Application No: CM/16/20/PL
Site Address: Langford Horsemere Green Lane Climping BN17 5QZ
Description of works: Variation of condition 2 imposed under CM/64/19/PL to substitute House Type F floor plans & House Type F elevations.

Thank you for your internet representation made on 22nd June 2020 which has been recorded as an objection with the comments as follows:

Project:
LANGFORD
HORSEMERE GREEN LANE
CLIMPING
Drawing Title:
HOUSE TYPE-F1
ELEVATIONS

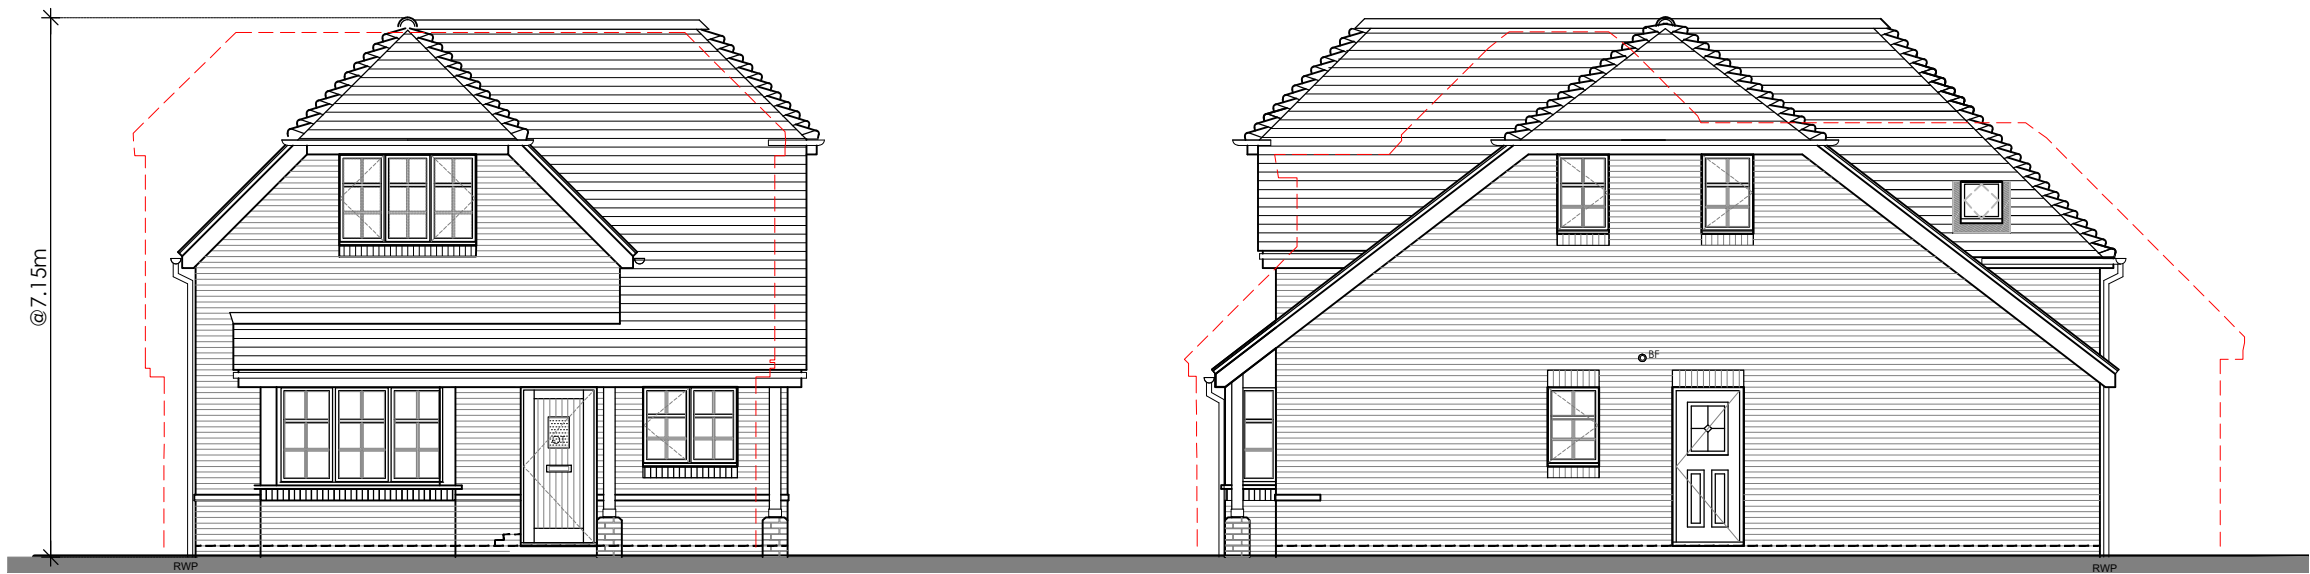
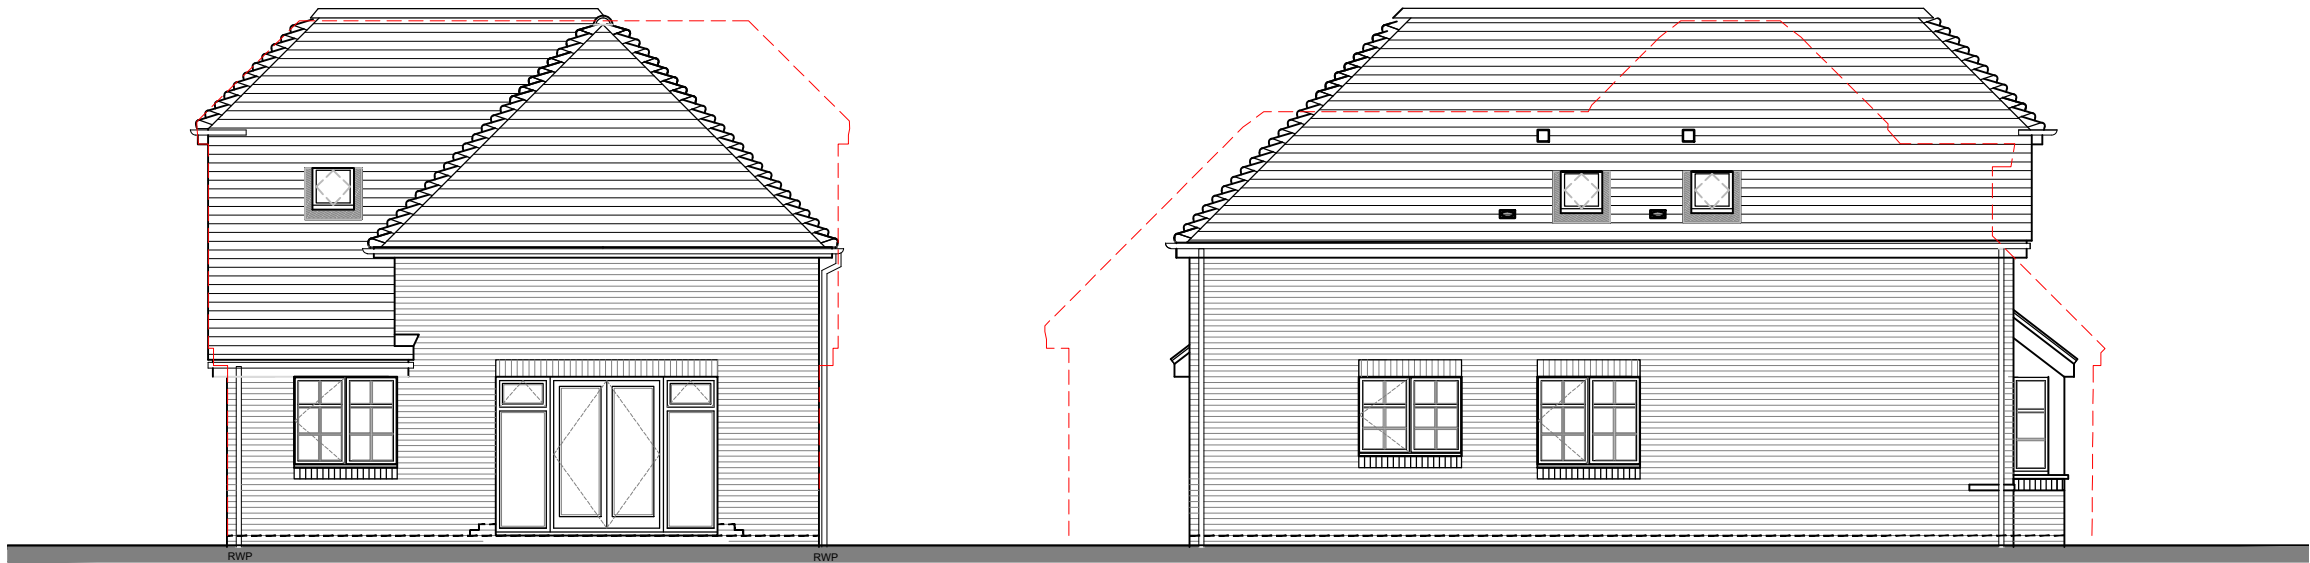
I wish to object to the amended plans that the applicant has submitted.

Due to the proximity of the proposed new building it is essential that the design does not overshadow, create privacy issues or impose on existing properties. According to the applicant Arun District Council requested the height of the original design be lowered. Subsequently the applicant redesigned the house as a chalet bungalow and the plans were approved. Unfortunately they have resubmitted plans for a 2 story house. Nothing has changed, this design not appropriate and we feel it is imperative the amended plans are refused.
